TOWN AND COUNTRY PLANNING ACT 1990 FULL

Reference: H03-0797-24 **Date of Decision:** 14th November 2024
Applicant: Mrs J Wenman
1 Herdsmans Close
Deeping St Nicholas
Spalding
PE11 3AE
Location: 1 Herdsmans Close Deeping St Nicholas Spalding
Description: Garage extension to form annexe

DRAWING NUMBER	REV
RJW-2609-24-01

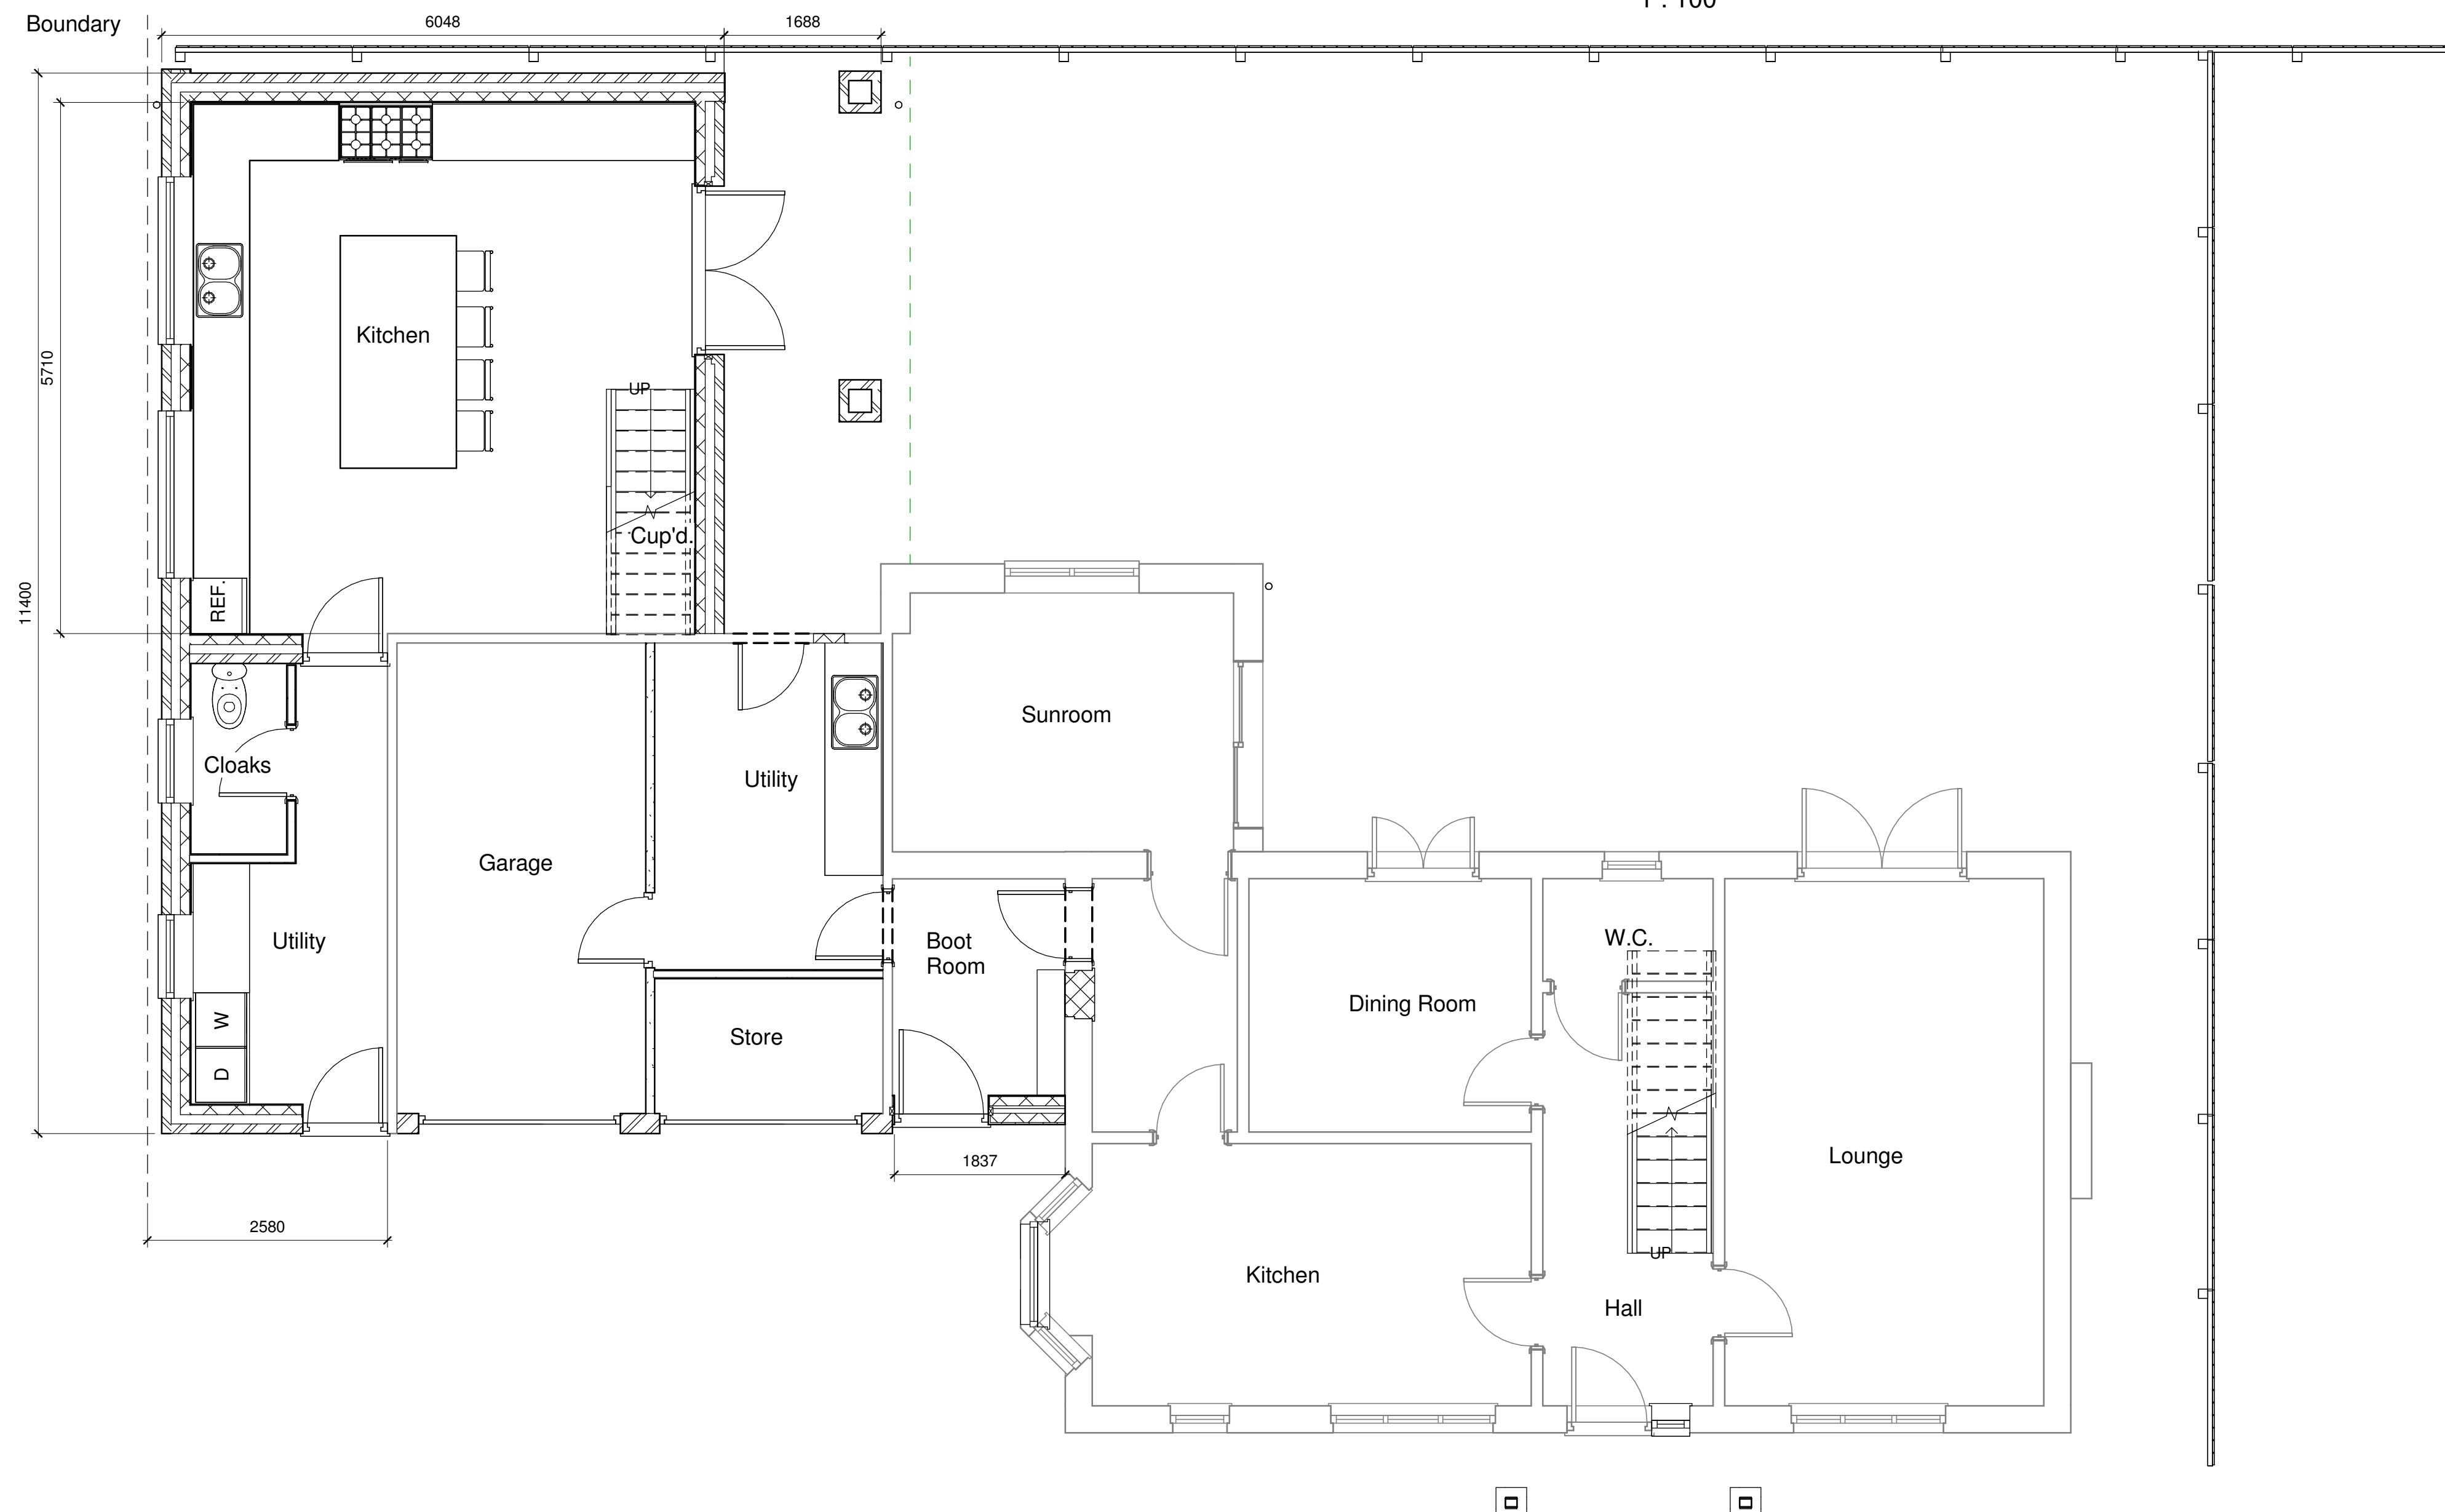
- 1 The proposed extension would represent a disproportionate form of development compared to the main dwelling. The proposed extension would be an incongruent form of development that would not be a suitable form of development within the street scene. The proposed extension would be located adjacent to the highway and would be of a significant scale compared to the main dwelling. The siting and scale of the proposed extension would therefore have a negative impact on the street scene. The scale of development would still be out of keeping with the area and appear overly dominant when compared to the host dwelling.

The proposed annexe is of a significant size compared to the main dwelling and there would be limited reliance on the main dwelling. The proposed annexe is therefore not considered to be subservient or ancillary.

The proposed development would not be subservient or proportionate to the host dwelling. As such, the proposed development would fail to conform to guidance set out within the National Design Guide, the National Planning Policy Framework (NPPF) (December 2023), and the South East Lincolnshire Local Plan (the Local Plan) (2019). The proposed development is therefore considered to have an unacceptable impact upon

the character of the area and is thus contrary to Policies 1, 2 and 3 of the Local Plan and Section 12 of the NPPF.
